PLANNING - LEVEL III REVIEW (14-526): MMC Congress Street Medical Building (285KSF) (19 procedure rooms, 64 patient rooms, licensed bed count remains 637)
Institutional Overlay Zone

IOZ - ZONING ANALYSIS

CS.2 Site Line Analysis

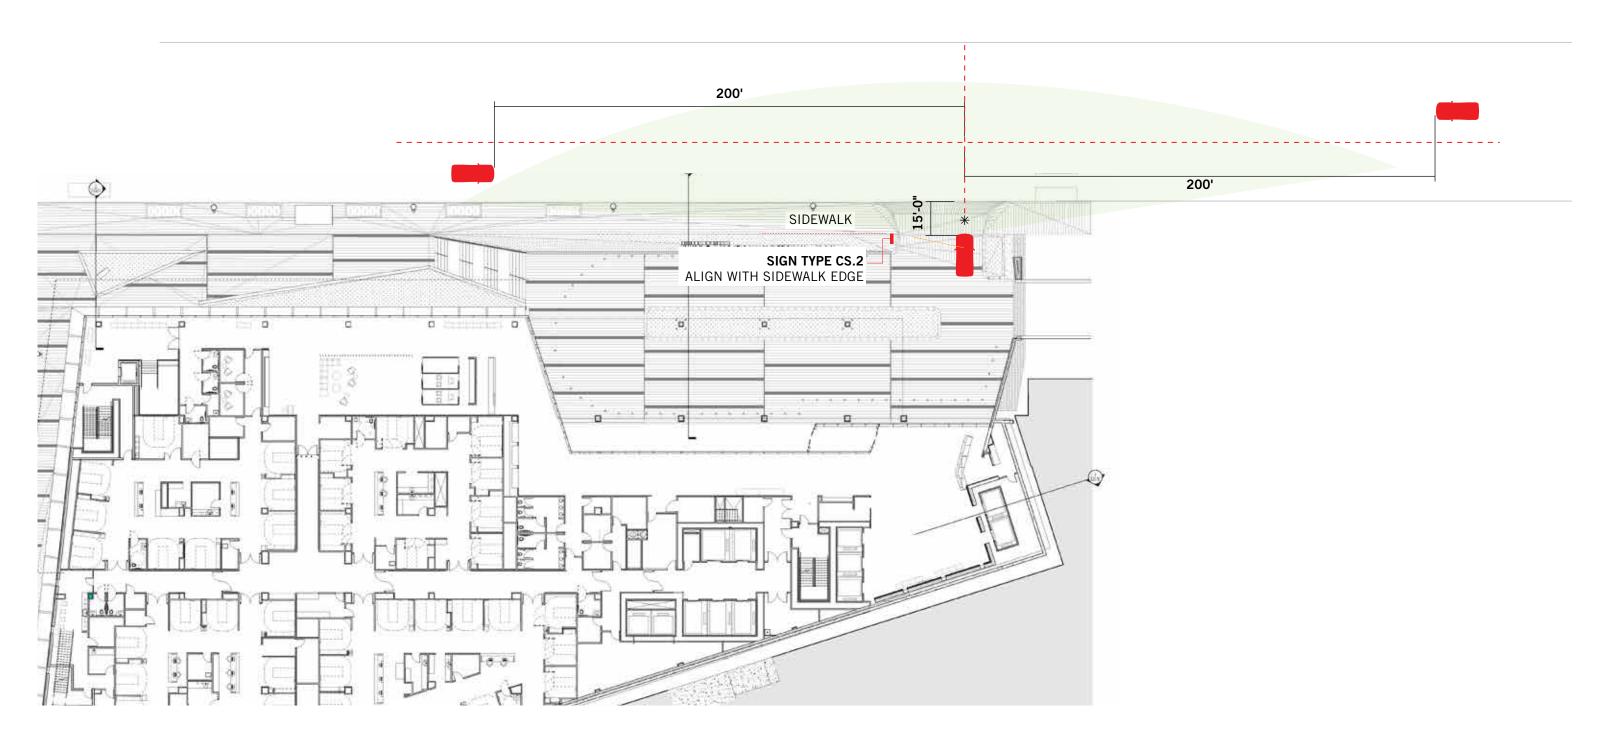
g. Noise and Vibration		
	h. Signage and Wayfinding	Revised sign plan still under review.	Please provide revised sign plan per prior comments. Provide sight line analysis
